10 January 2022

SSD-21190804 – PROPOSED CHANGE OF USE FOR THE PURPOSE A LIQUID MANUFACTURING FACILITY ON LOT 201 OF THE HORSLEY LOGISTICS PARK AT 12 JOHNSTON CRESCENT, HORSLEY PARK

Fairfield City Council is in receipt of the Department's request for advice on the applicant's Response to Submission, dated 18 November 2021 for the abovementioned State significant development (SSD) application to the Horsley Logistics Park.

Figure 3 Locations of Receptors

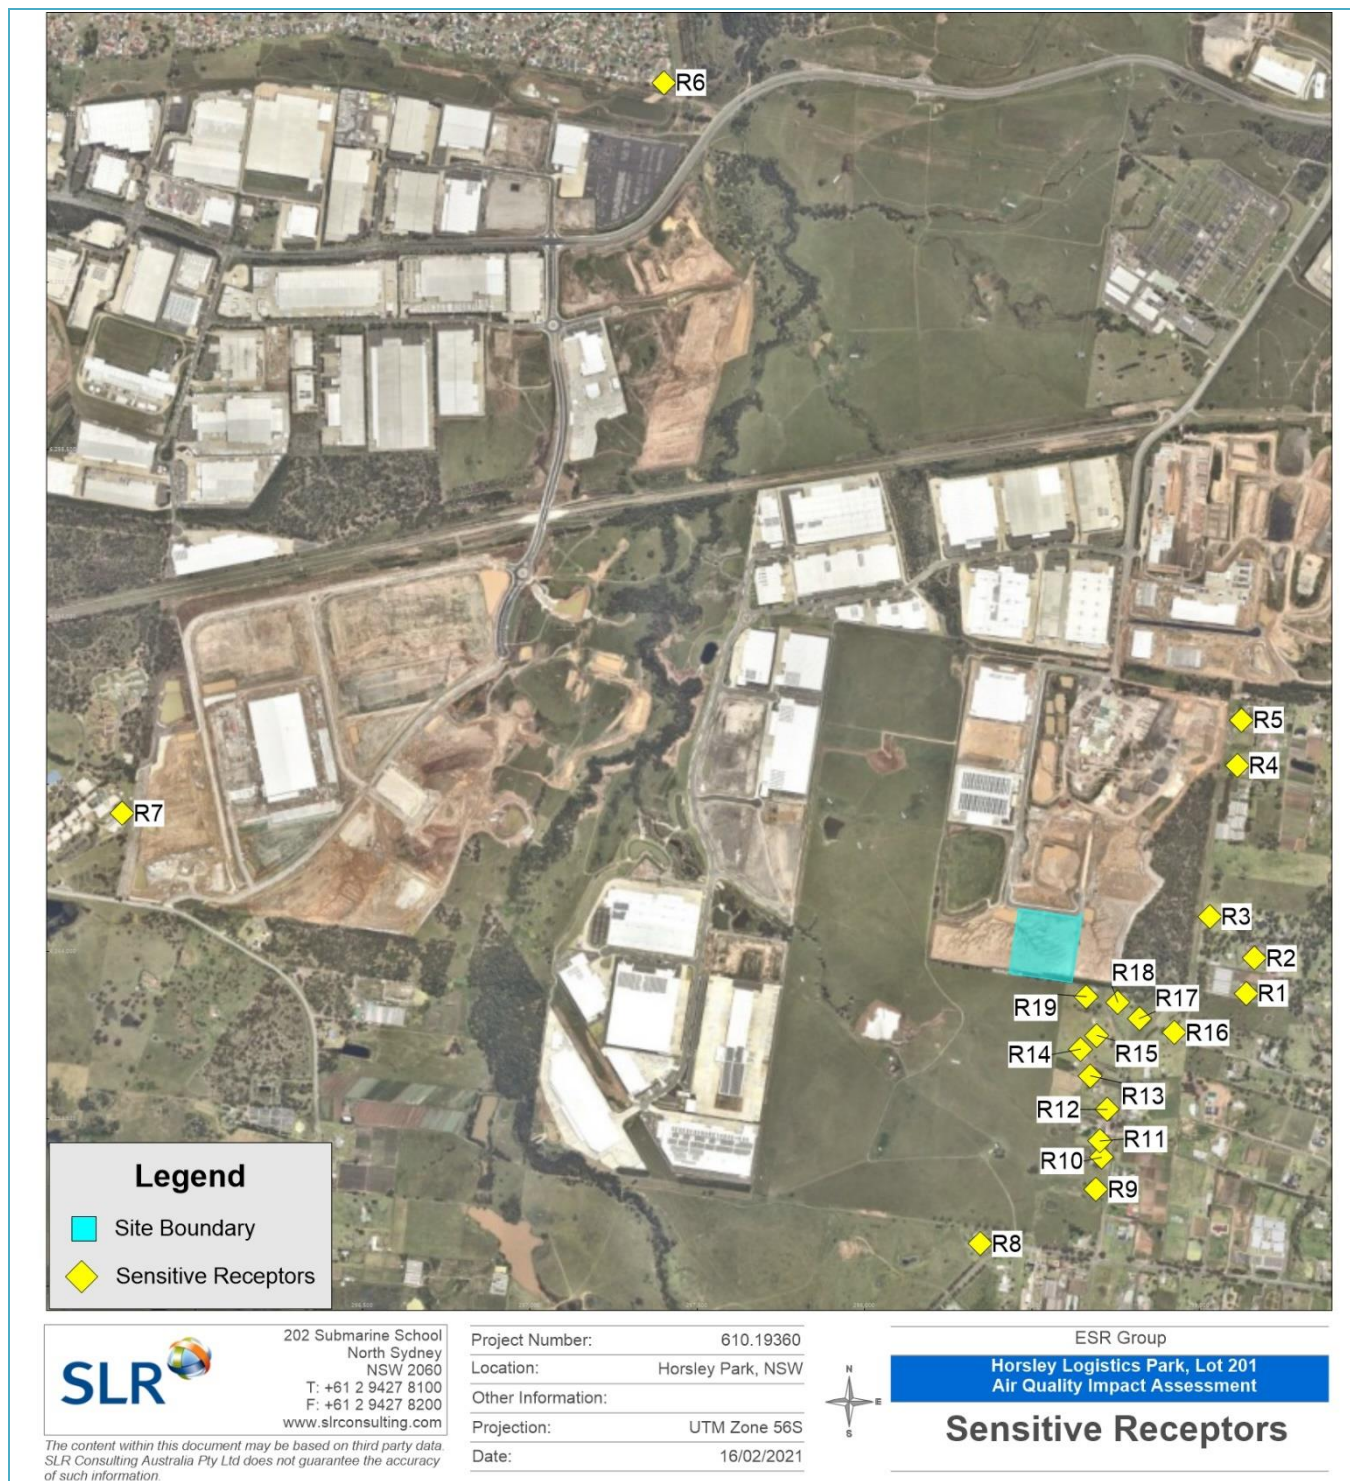
- The consultant shall confirm the type of receptors (residential, school, childcare, businesses etc) indicated in Table 3 Details of identified receivers.

- The consultant shall demonstrate that an air and odour impact assessment has been undertaken on future neighbouring tenants/occupants of the warehouses located within the Horsley Logistic Park as they have not been identified as receptors. A quantitative assessment of the air quality and odour impacts of the development (construction and operation) on surrounding landowners, businesses, and sensitive receptors, in accordance with the relevant Environment Protection Authority guidelines.
